South Humber Bank Energy Centre Project

Planning Inspectorate Reference: EN010107

Document Reference 8.10: Applicant's Comments on Deadline 2 Written Representations

Applicant: EP Waste Management Ltd
Date: January 2021

Document Reference: 8.8 Key & Watercourses and Flow Direction Diagram

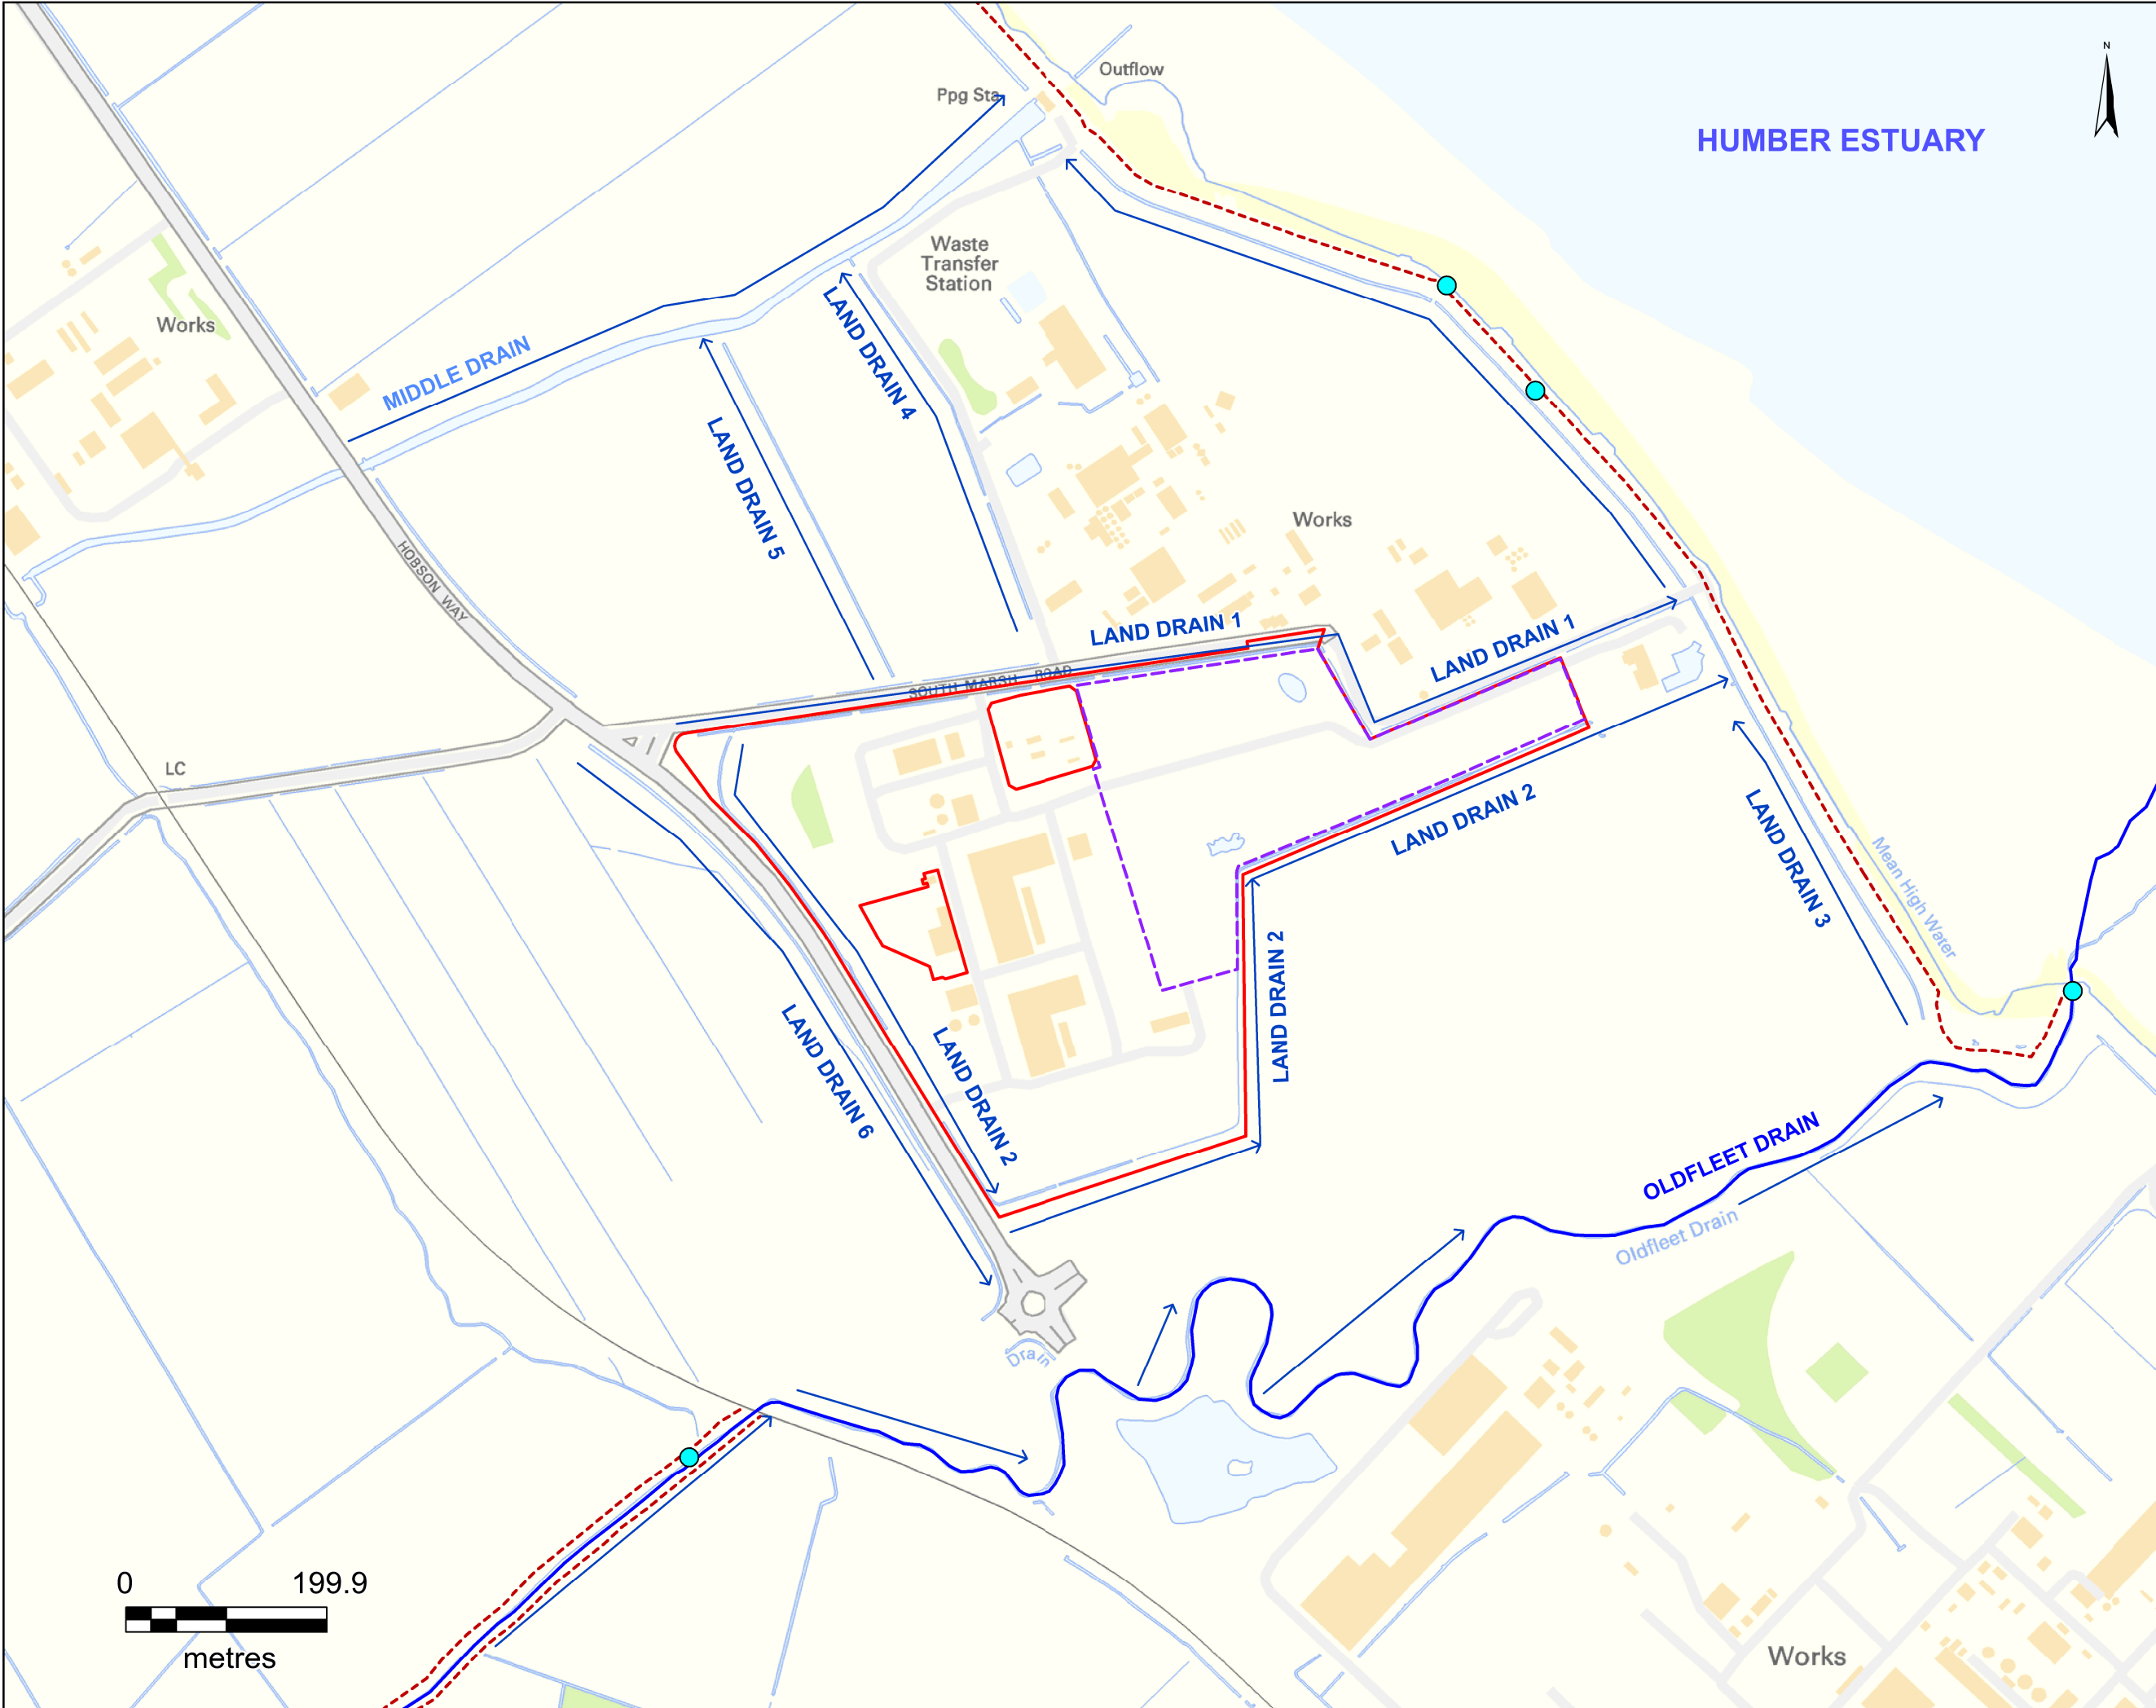
As a matter for correction on the ‘Key Watercourses & Direction’ drawing ‘Land Drain 3’ is shown as flowing towards ‘Oldfleet Drain’ this is incorrect all flows from the catchment flow to the gravity outfall/Middle Drain pumping station.

- 2.1.2 In response to the North East Lindsey Internal Drainage Board's Written Representation the Applicant includes an updated version of the 'Key Watercourses & Direction' Figure at Deadline 3 (Document Ref. 8.8) following the IDB's point of correction on the direction of flow. This correction does not alter the findings or conclusions of the reports that accompanied the DCO application including the Environmental Statement (Document Ref. 6.1 to 6.4).
